From: Simon Davis
Sent: 19 March 2019 11:32
To: [REDACTED]
Subject: RE: BN/50/18/PL The Fallows

From: Laura Gibbons
Sent: 04 January 2019 13:55
To: Simon Davis [REDACTED]
Subject: RE: BN/50/18/PL The Fallows

Standard Detail
High Storage Soakaway

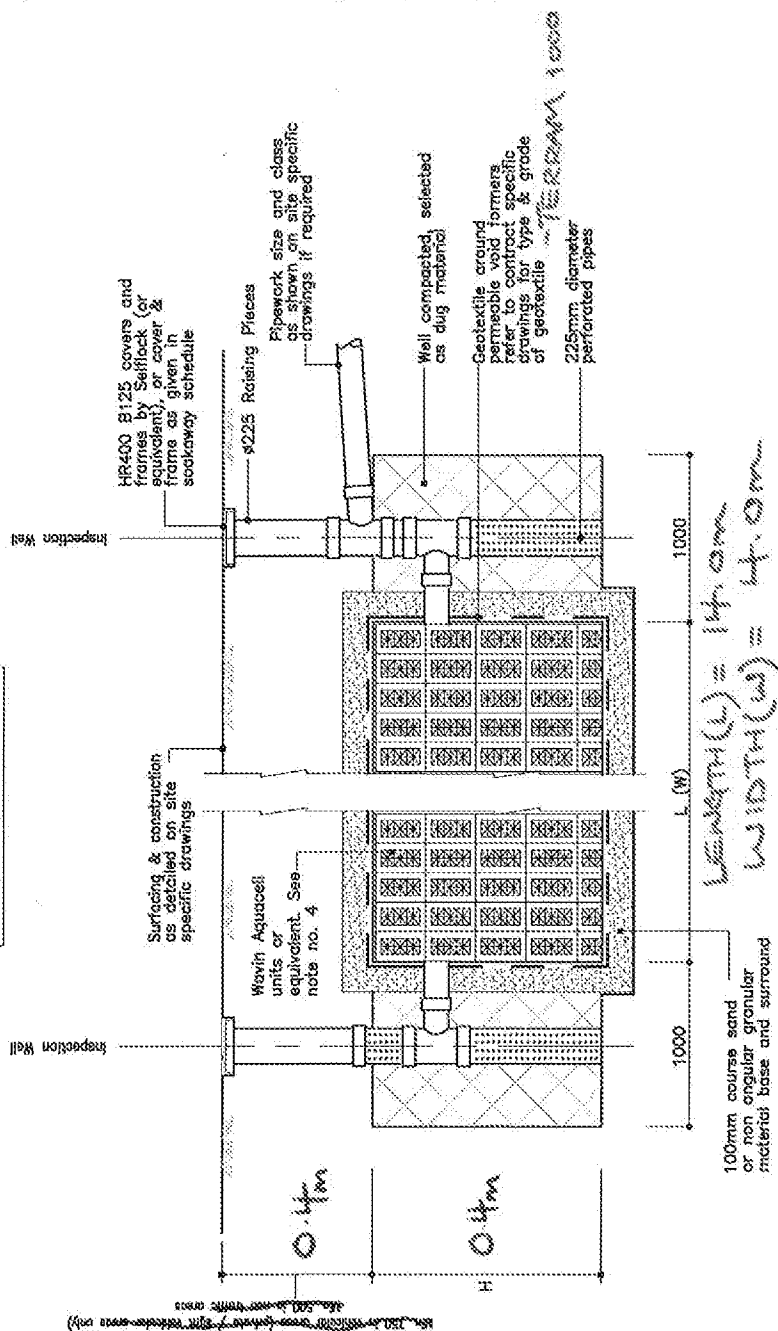
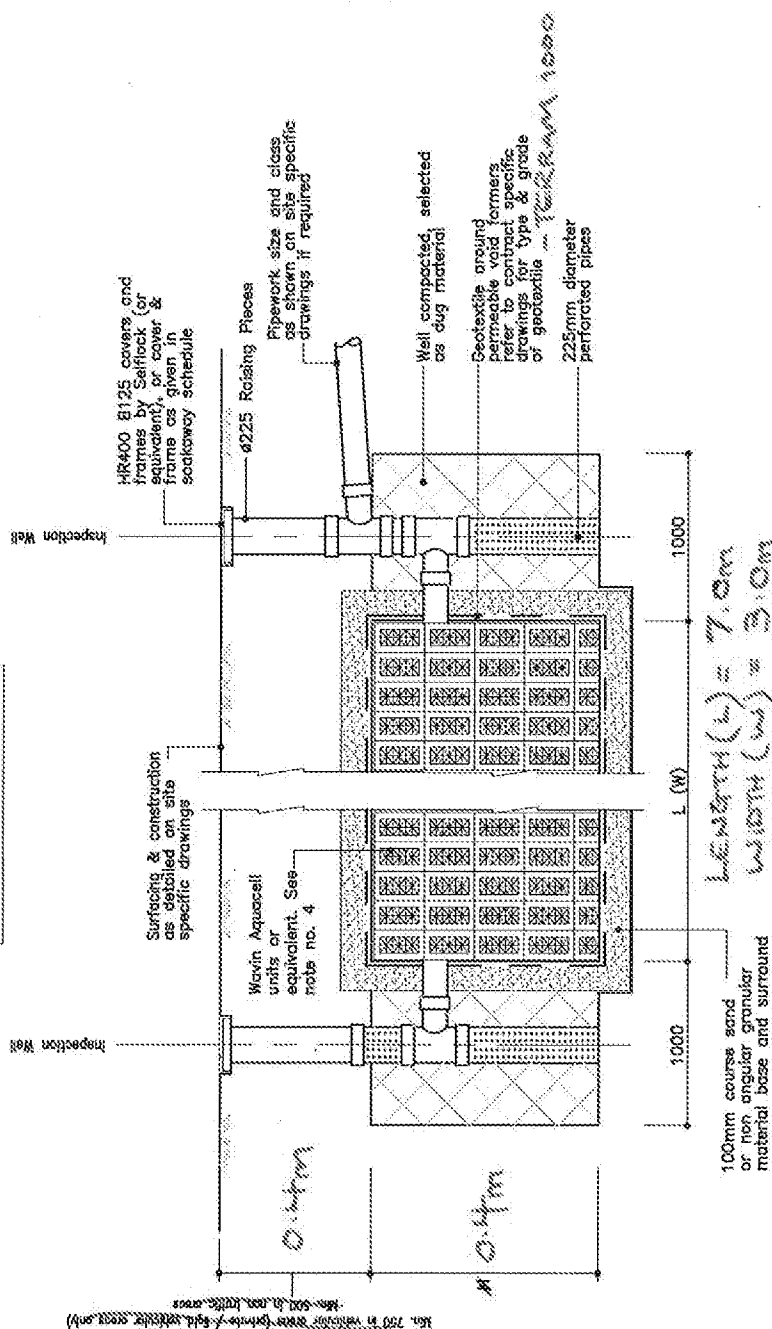
It is unclear from the supplied information if three consecutive infiltration tests were completed as is required. The information also states that a piezometer was installed to monitor ground water levels. These ongoing monitoring results have not been provided.
